I wish to pass comment on
planning application 3/2025/0056
104 COTTAGE, PARSONAGE ROAD,
WILTSHIRE, BS1 4AG

PROPOSED ENCLOSURE OF OPEN VERANDA
WITH WINDOWS AND DOORS TO FORM A
PORCH AND INSTALLATION OF SOLAR
PANELS TO THE ROOF OF THE
REAR KITCHEN EXTENSION

NW ELEV
1 TO 100

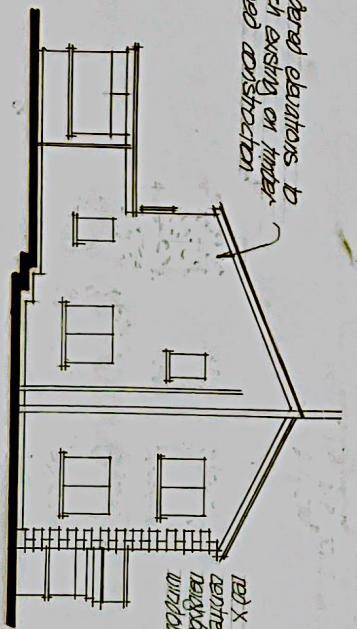
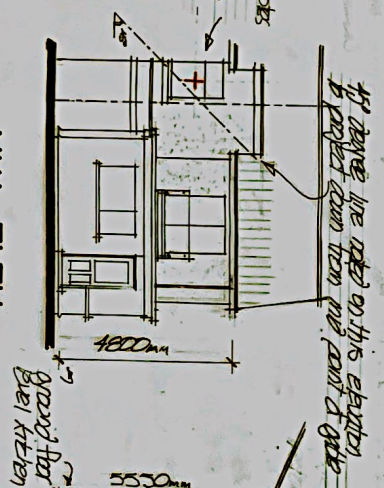
Firstly I note there is no planning
permission sought for the change to
BED 2 windows

on the NW elevation, simply
a mention under 12/12/24 - Beo 2
windows amended to as built.

The original planning permission
granted in 2022 shows a
 Juliet balcony and no window
to the NW elevation next to
the gable end. There has been
no notification to neighbours
of a change or permission
granted. Had the configuration
looked like this on the original
plan I would have made an
objection then, as it was not
I will comment now.

large sycamore tree [REDACTED]
which blocks the view from the
balcony of Ivy Cottage to the patio
area in [REDACTED]. However the
window has a direct view to this
area which creates [REDACTED]

[REDACTED] If
the window is to remain, I would
request a non opening, obscured
glass window be fitted. From a
safety aspect, there are escapes
available through the balcony door
and from the window on the S.W
elevation (also not on the original
planning request). I would hope this
[REDACTED]
